TM312-03F01 Ardex Warehouse Kemps Creek RfS Comments (r1)

## **Proposed Ardex Warehouse & Manufacturing Facility, 657-769 Mamre Road, Kemps Creek - Response to submissions - Noise and vibration**

Renzo Tonin & Associates (RT&A) has been engaged by The Trust Company (Australia) Limited on behalf of Altis Frasers JV Pty Ltd to undertake an operational and construction noise and vibration impact assessment (NVIA) to accompany the State Significant Development Application (SSDA) 25725029 for the proposed Ardex Warehouse and Manufacturing Facility at the proposed Lot 12, 657-769 Mamre Road, Kemps Creek (the Proposal).

Plot Date: 20/07/22 - 14:56
Layout: TM312 NOISE CONTOURS (r5)
GIS File: R:\AssoSvd\Projects\TM301-TM350\TM312 ale Ardex Warehouse Kemps Creek\6 Figures & CAD Out\01 GIS\TM312-01 MAMRE RD PRECINT-ARDEX (r0).qgz

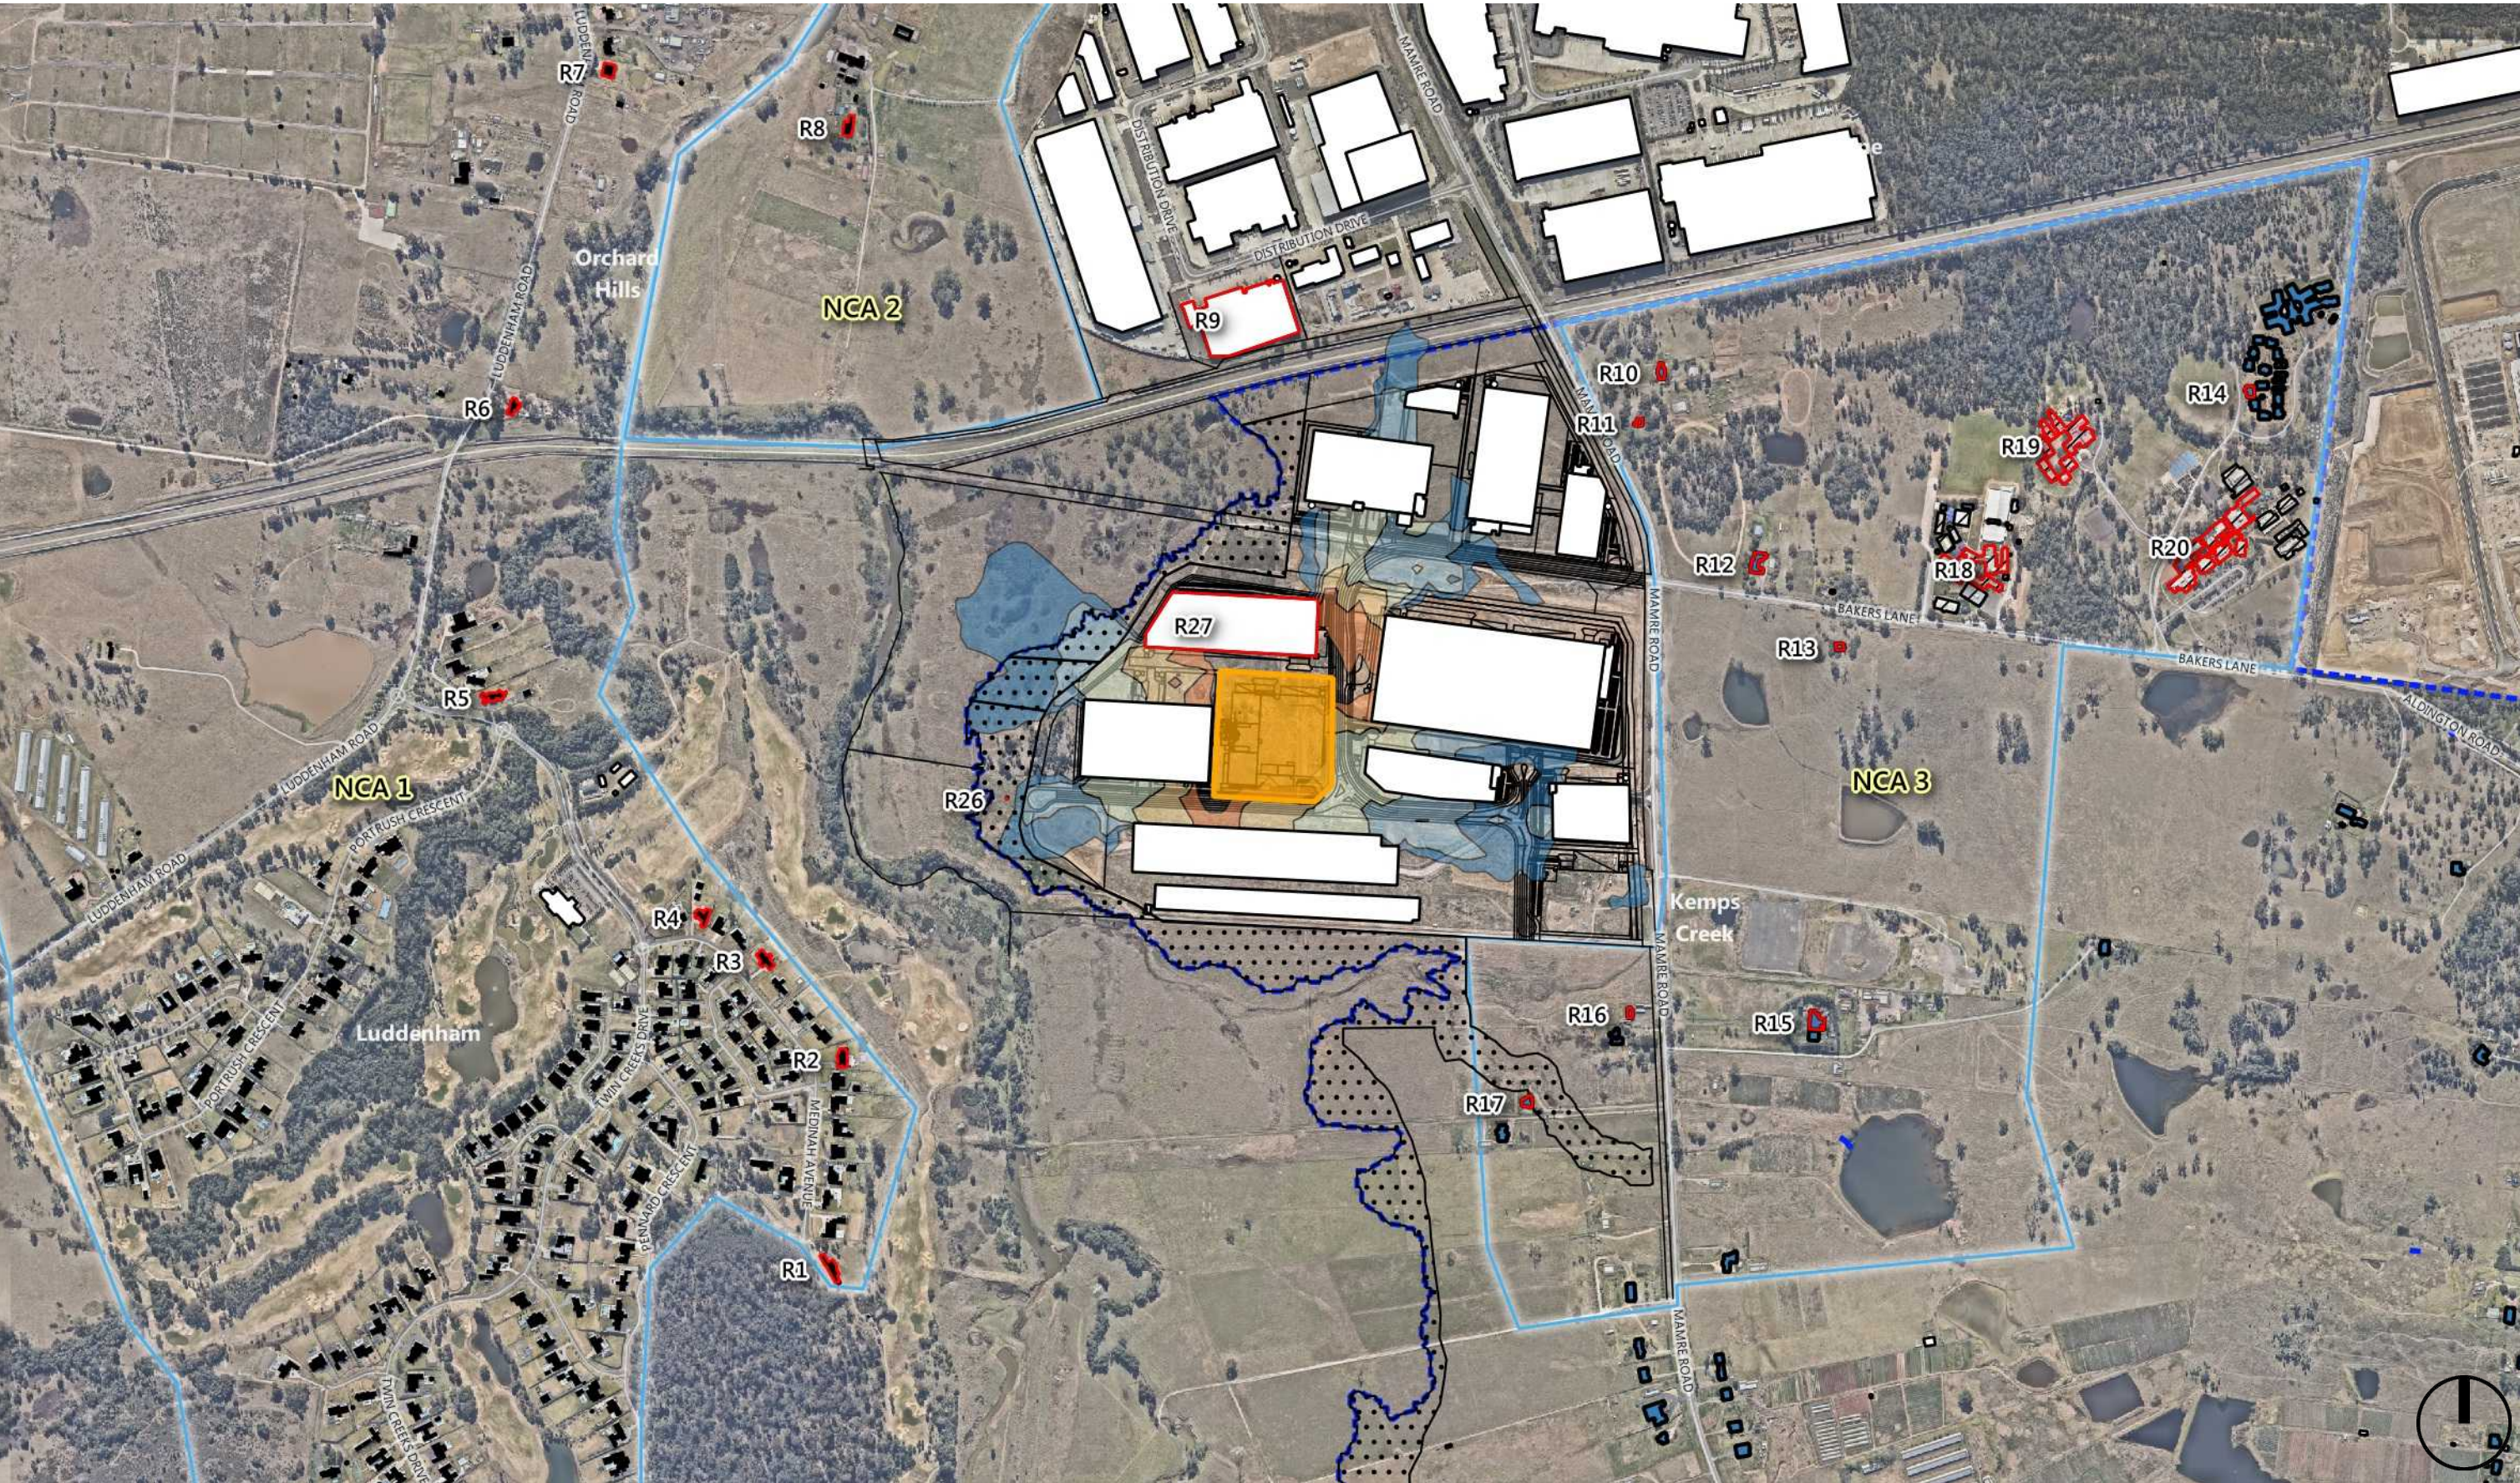
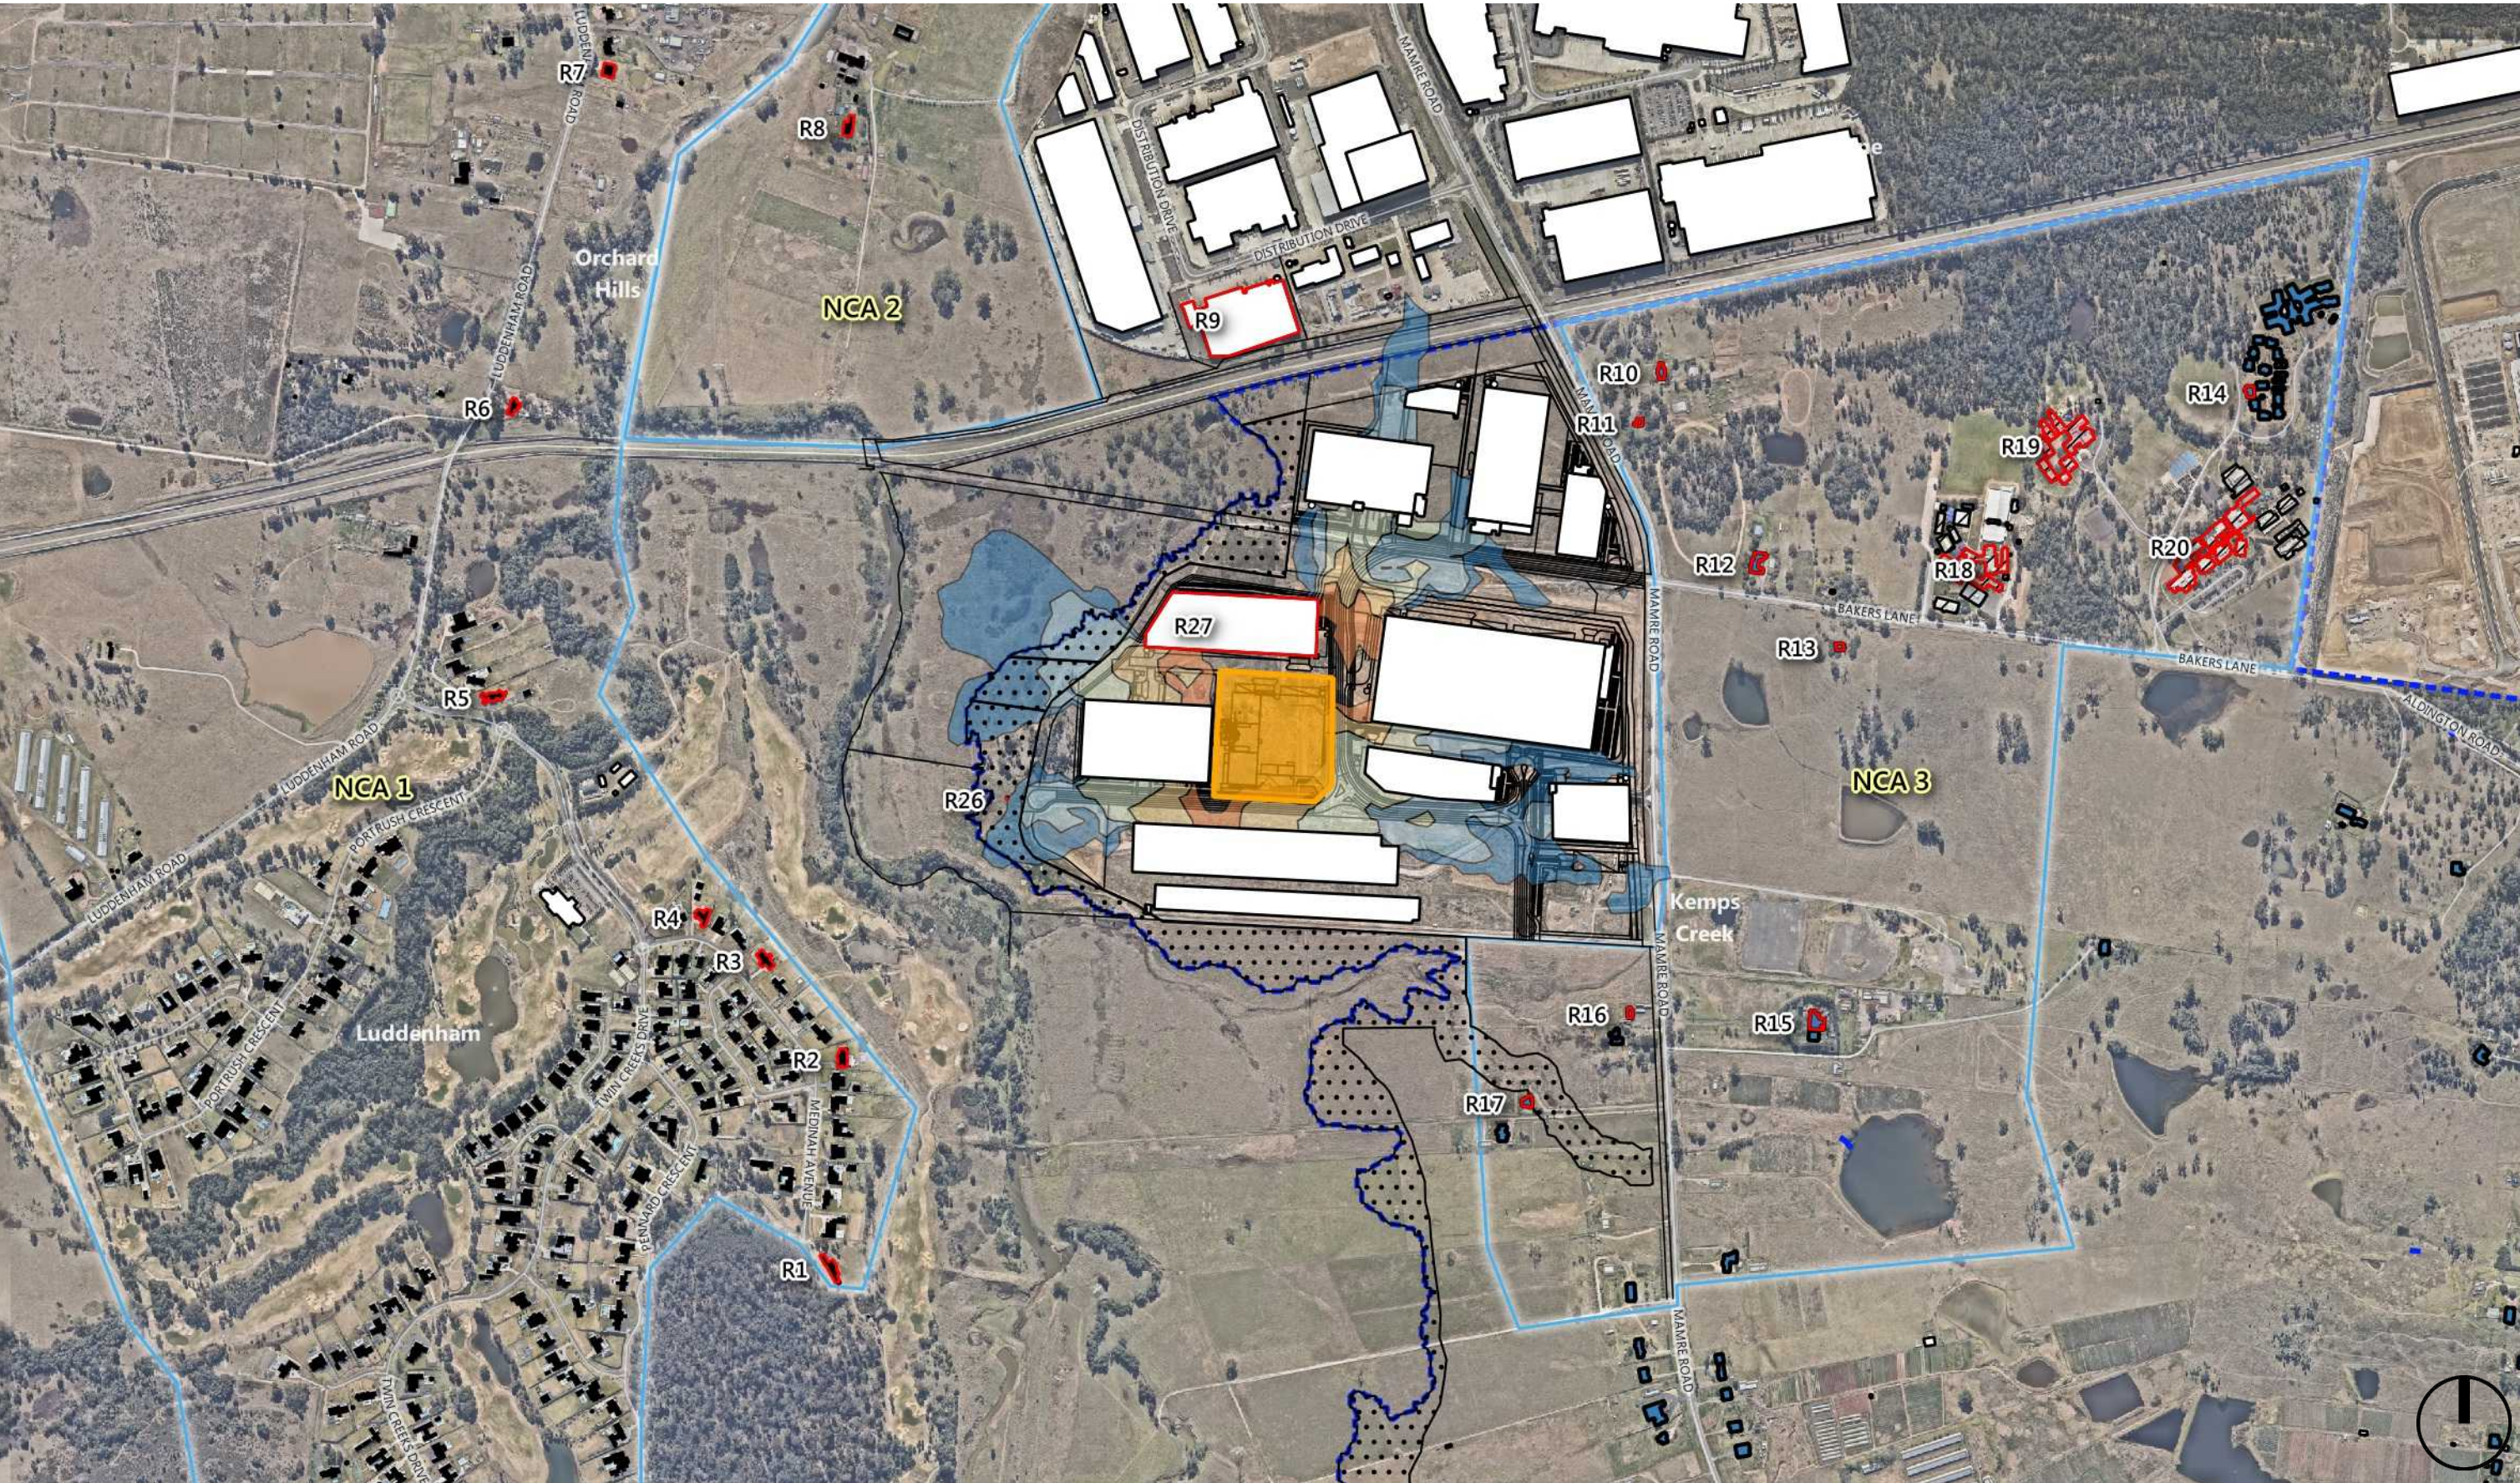
Item	Comments on NVIA	RT&A responses
18	The Department notes that Appendix B1 of the NVIA detailing the locality map, sensitive receiver type identification and operational assessment representative receiver locations is not provided. The Department also notes that Appendix E (Sections E.1 and E.2) detailing the predicted operational noise contours is not provided. The Applicant is required to update the NVIA to include Appendices B1 and E.	The updated SSDA NVIA includes these figures in: <b>Appendix B.1</b> - Locality map, sensitive receiver type identification and operational assessment representative receiver locations <b>Appendix E (Sections E.1 and E.2)</b> - Operational noise contours
19	The Department notes the NVIA considers impacts associated with the construction and operational phases of the development and the cumulative impacts. As discussed under the general comments above, the NVIA does not consider the proposed wastewater treatment plant in sufficient detail. The Department requires the Applicant to update the NVIA to include the proposed operational details of the wastewater treatment plan.	Wastewater treatment plant has been added into the updated modelling and predictions. Refer to response Item 2.
